## Inspector's Report ABP-315789-23

<b>Question</b>	Whether the widening and alteration of a gateway, is or is not development and is or is not exempted development.
<b>Location</b>	Darrynane More, Caherdaniel, Co. Kerry.
<b>Declaration</b>	
Planning Authority	Kerry County Council.
Planning Authority Reg. Ref.	EX 1045.
Applicant for Declaration	John Cox.
Planning Authority Decision	Is not exempted development.
<b>Referral</b>	
<b>Referred by</b>	John Cox.
<b>Owner/ Occupier</b>	John Cox.
<b>Observer(s)</b>	None.
<b>Date of Site Inspection</b>	14 February 2024.
<b>Inspector</b>	Daire McDevitt.

REPAIRED ENTRANCE AFTER STORM DAMAGE

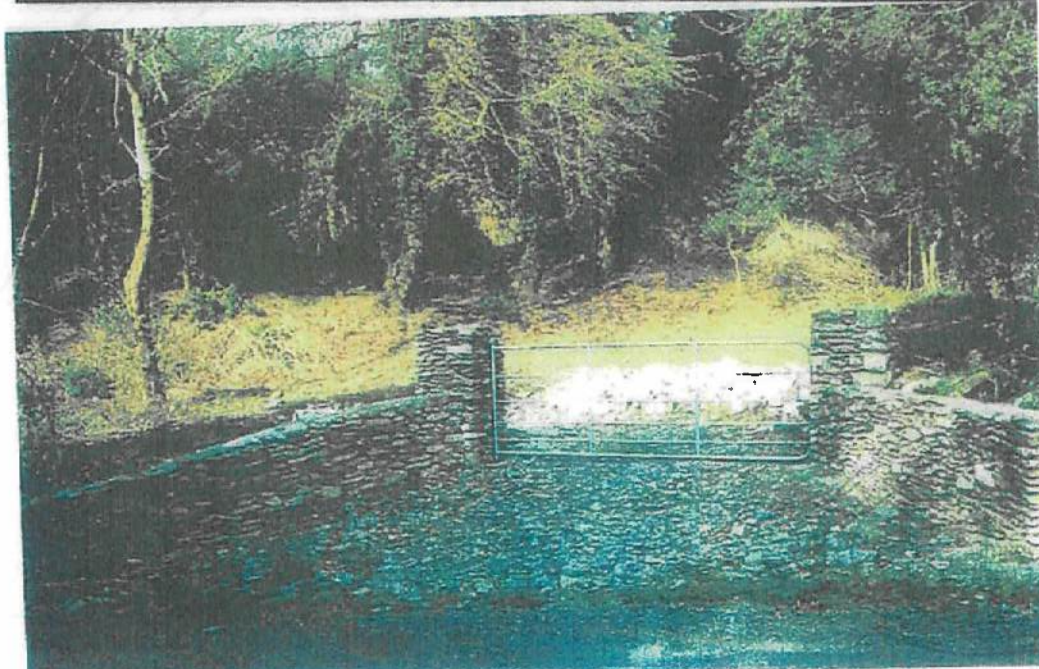
The development would endanger public safety by reason of traffic hazard or obstruction of road users. The development is located south of the junction with the Caherdaniel to Waterville Road with limited sightlines due to the vertical and horizontal alignment of the road at this point.

On balance and having regard to the forgoing I am of the opinion that that the matter subject to this referral is development and is not exempted development in accordance with Article 9(1)(a)(iii) restrictions on Article 6 exemptions, whereby the development consists of development that would endanger public safety by reason of traffic hazard or obstruction of road users.
